From: Sue Howell
Sent: 22 February 2018 17:37
To: Planning.Responses
Cc: David Easton
Subject: RE: Planning Consultation on: BR/331/17/PL

Comment from Greenspace

Further to submission of revised drawings 16-100-01 Rev E and 16-100-P101A re landscape condition 21, we reiterate our consultation comments of 13/12/2016 and also confirm that the detail now submitted has taken into account our recommendations of those comments and has amended and added to the landscape scheme accordingly. The additional planting now proposed to the area adjacent to Plot No 62 by the river is suitable for location and a welcome addition to which we would now agree.

Description of Works: Variation of conditions 2, 8, 12, 14 & 21 imposed
under BR/240/16/PL relating to approved plans.

DWG. NO: 16-100-P102

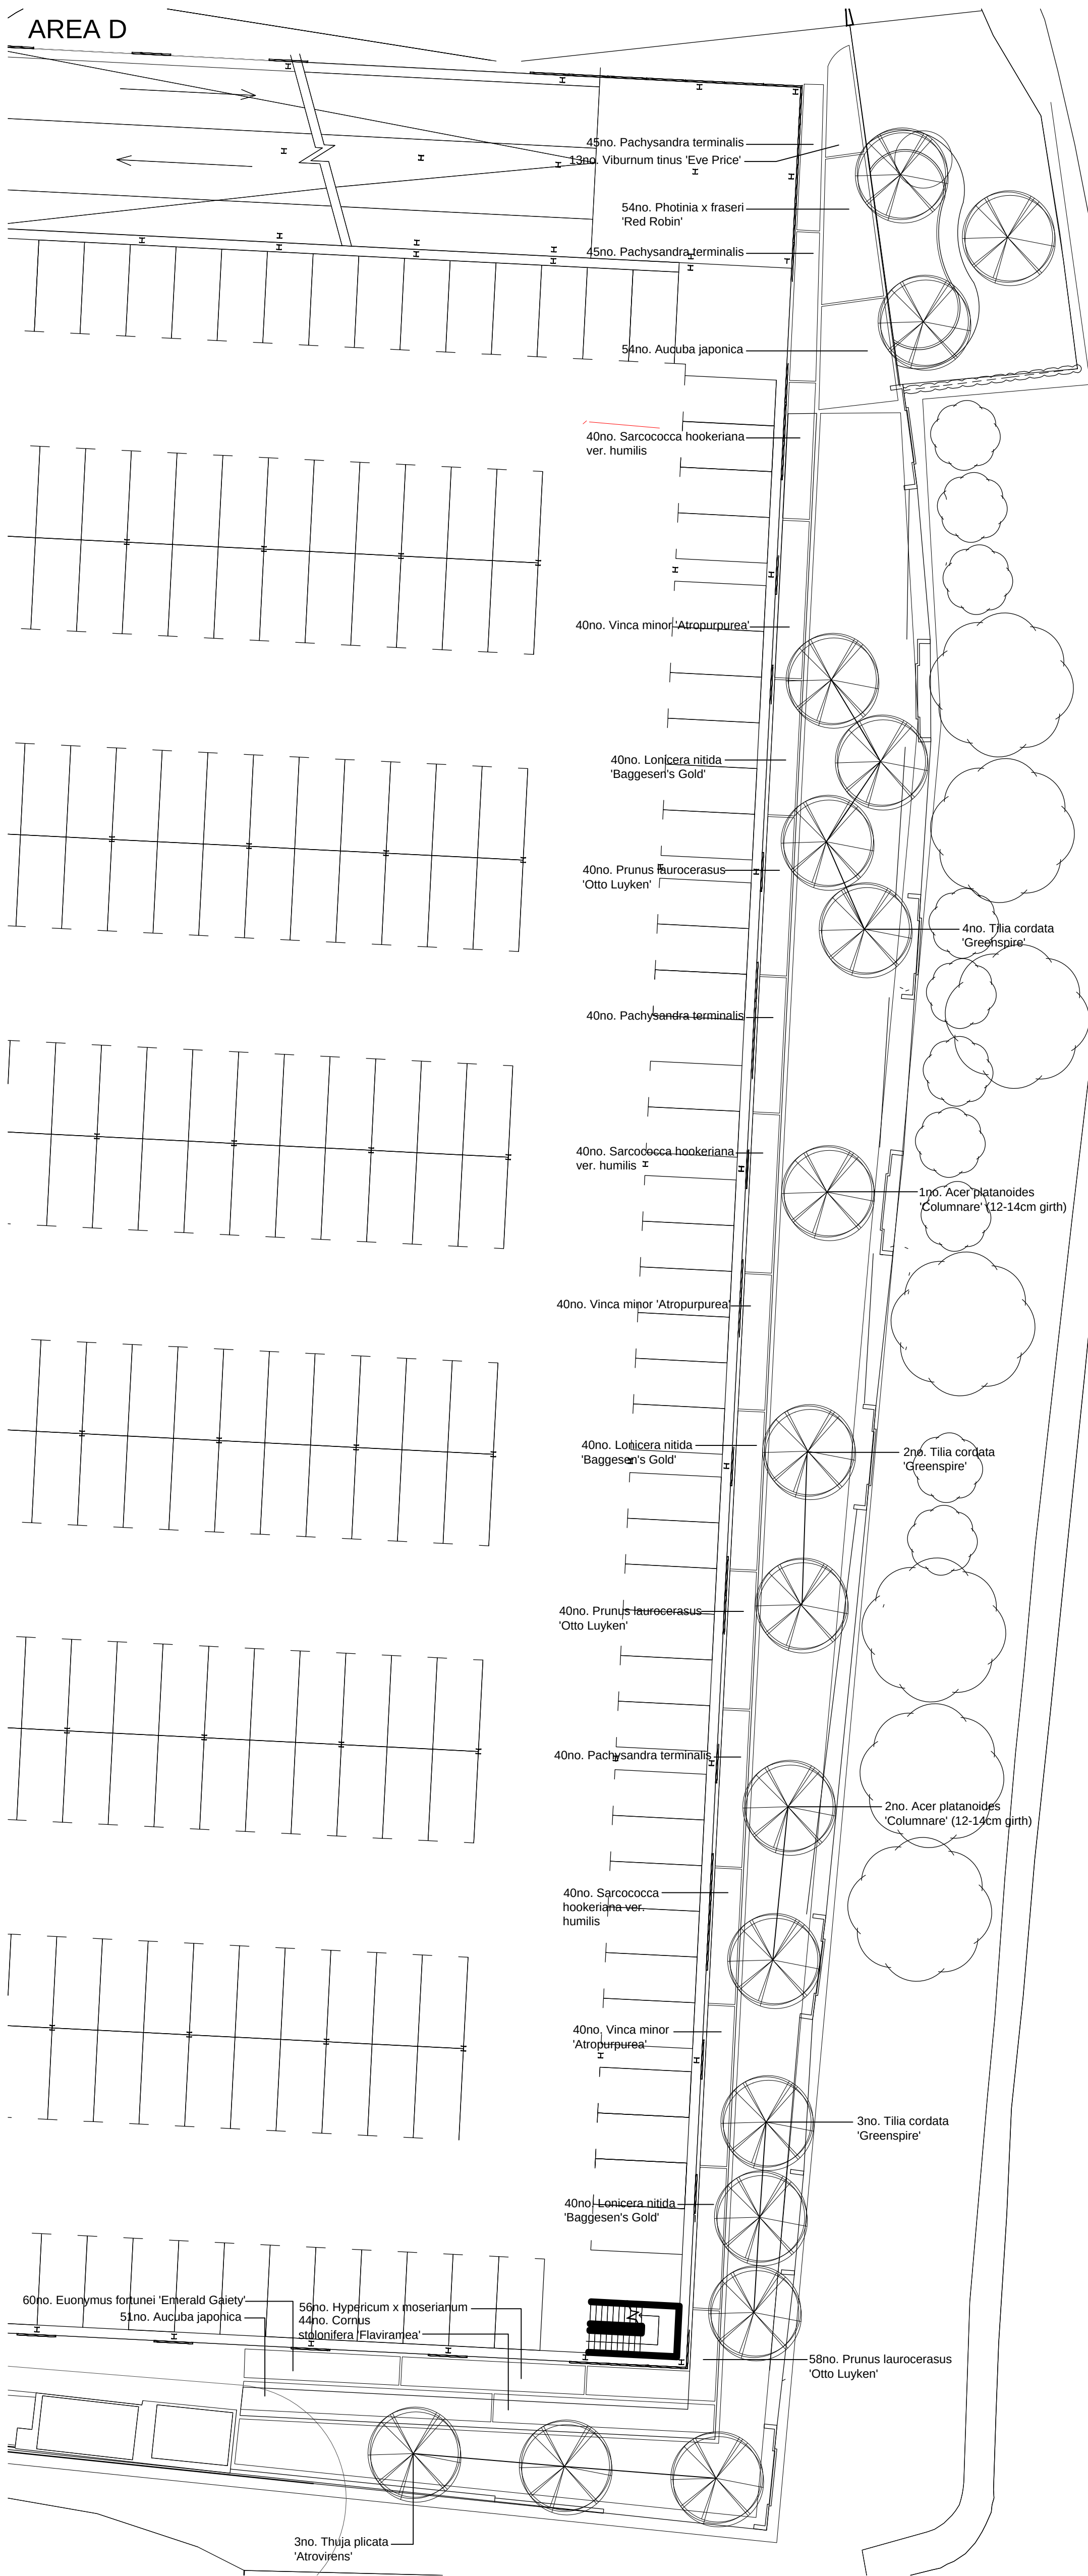
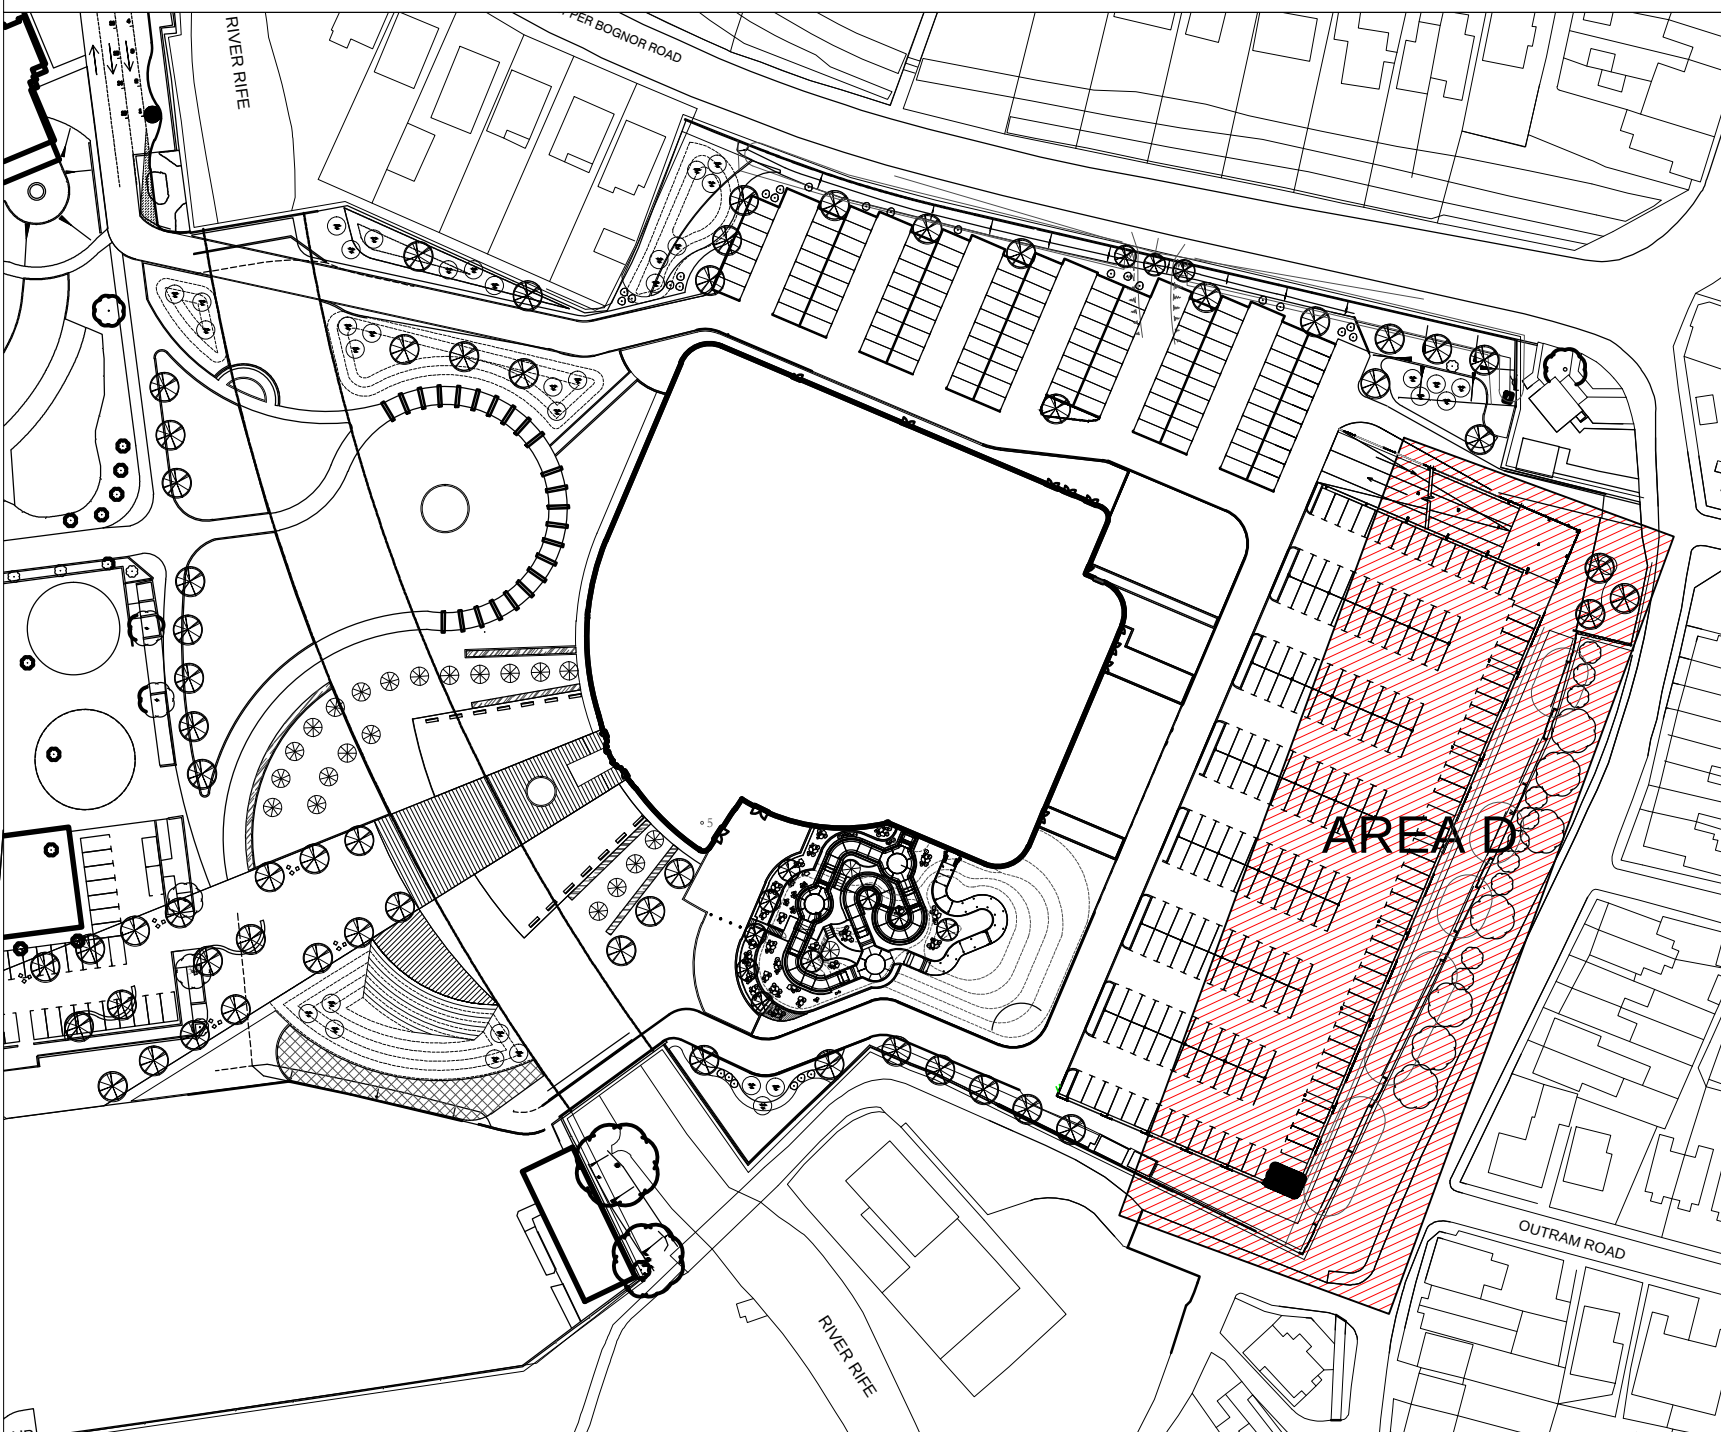
The detail regarding the Thuja plicata 'Atrovirens' is still shown as supplying these as clear stem of 1.8-2.0m and we again reconfirm that these would be required as branched to ground level and not clear stem in order to afford the greatest screening benefit.
